Application No: BE/149/20/PL
Site Address: 339 Chichester Road Bersted PO21 5AN
Description of works: Replacement of blockwork boundary wall with fence & new vehicular access. This site is in CIL Zone 4 (Zero Rated) as other development.

Thank you for your internet representation made on 9th February 2021 which has been recorded as an objection with the comments as follows:

Ref BE/149/20/PL

SITE PLAN

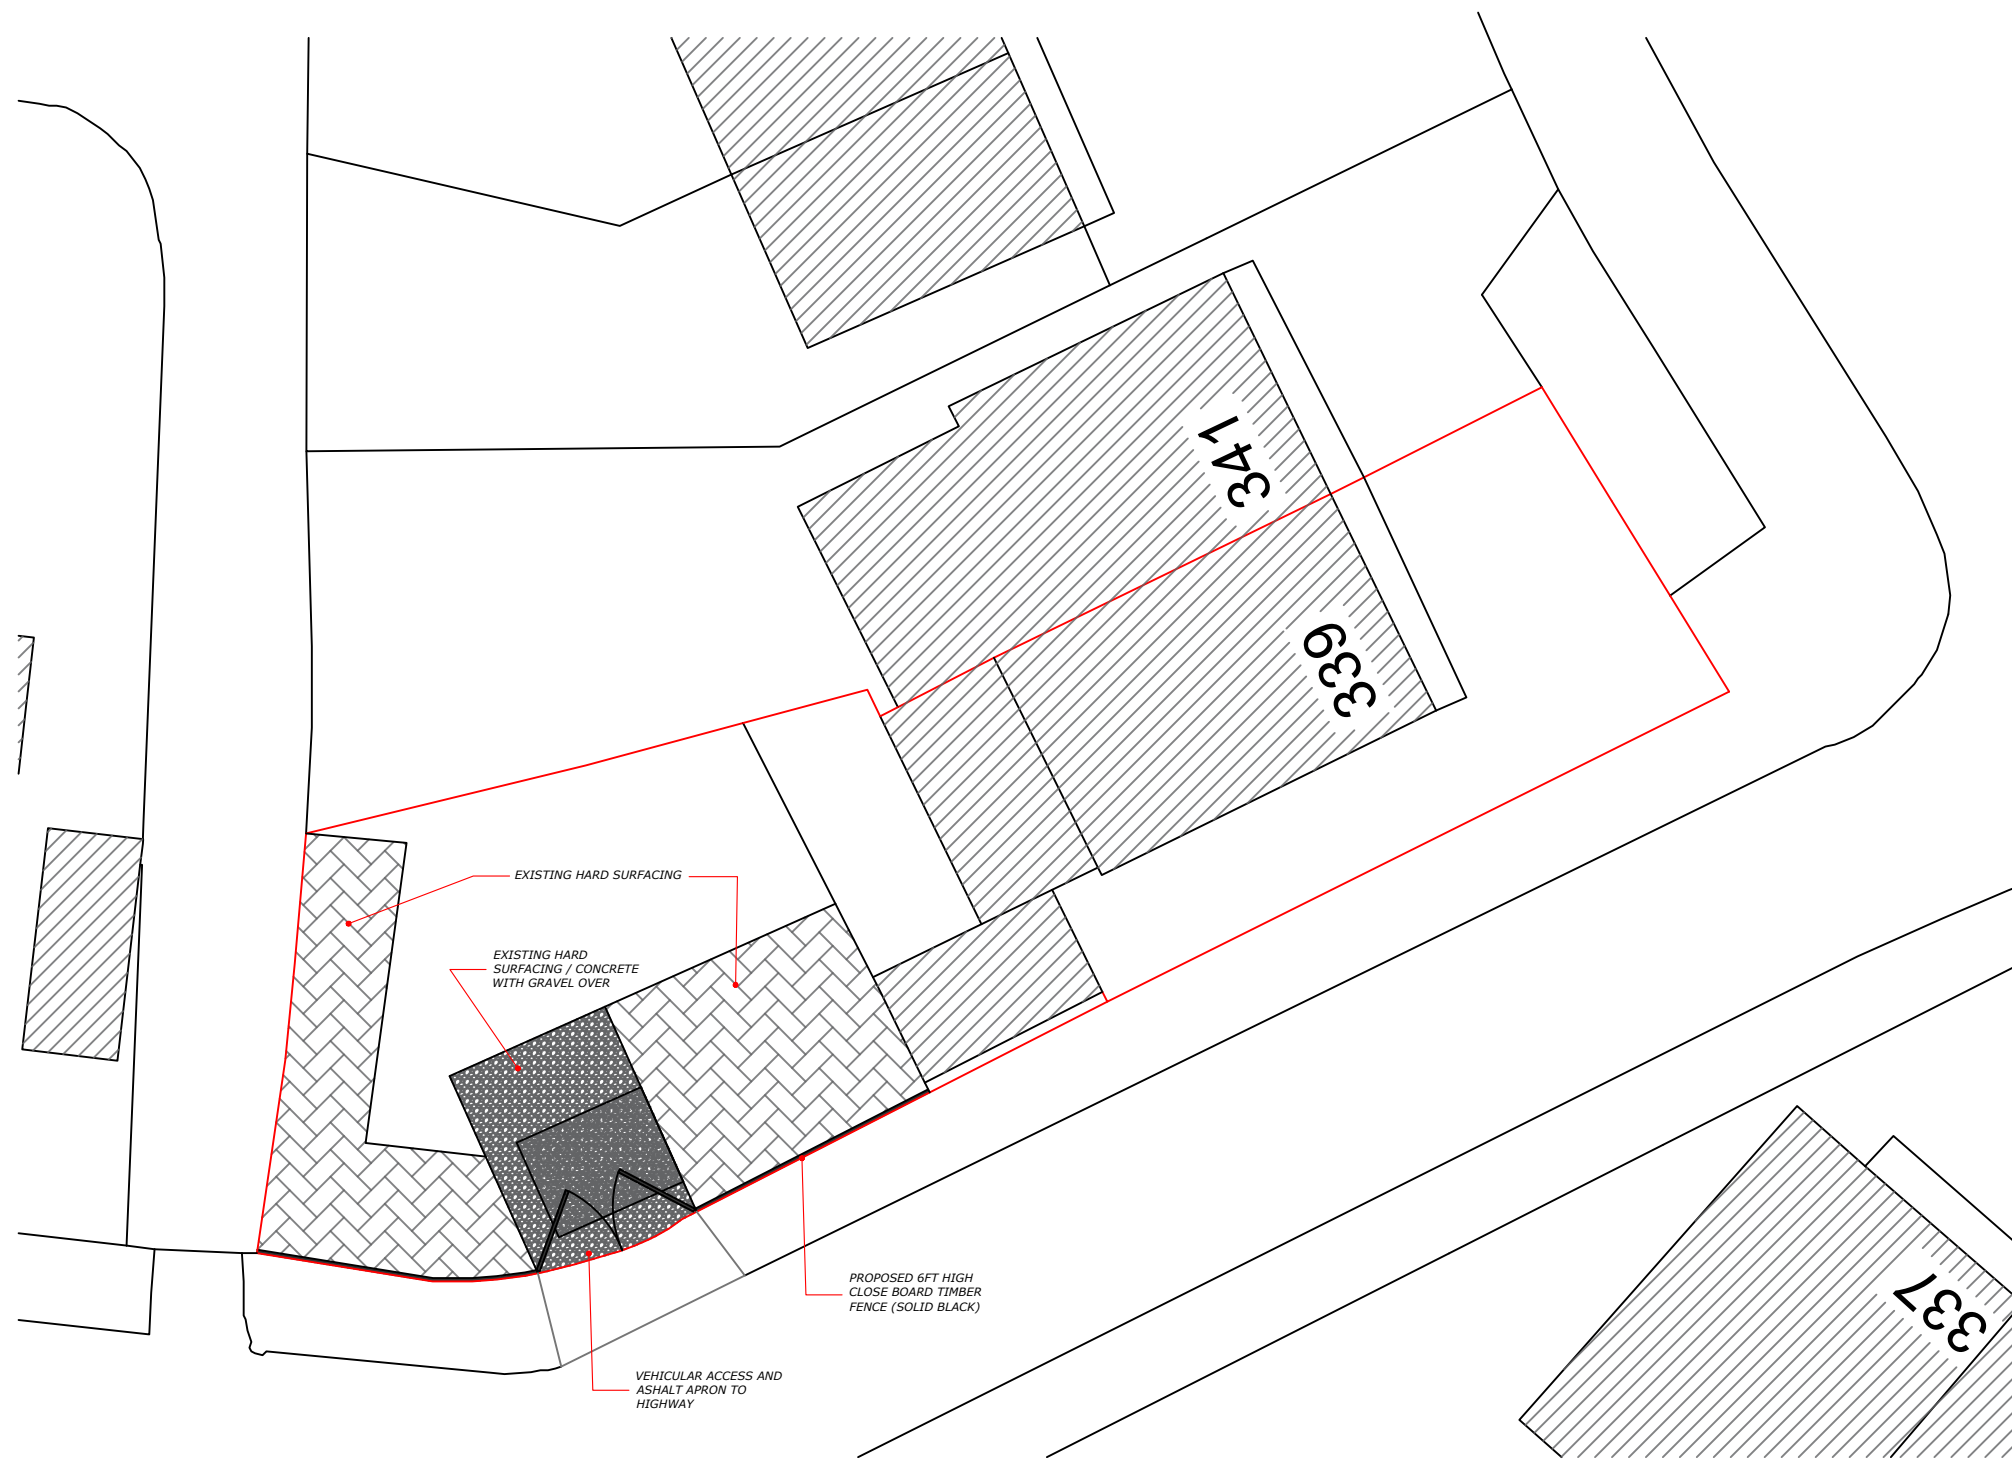
The recently installed dropped kerb is sited directly opposite access/exit to the rear of properties on Chichester Road creating crossroads. By allowing vans and truck to be accessing/exiting this proposed site opposite another road as residents vehicles are travelling up and down Bedford Avenue is a recipe for disaster, there have been many incidents on this bend.

The overwhelming argument against this proposal is safety, considering the speed of vehicles using Bedford avenue, as they take a short cut between Chichester road and chalcraft Lane, coupled with residents use of the road.
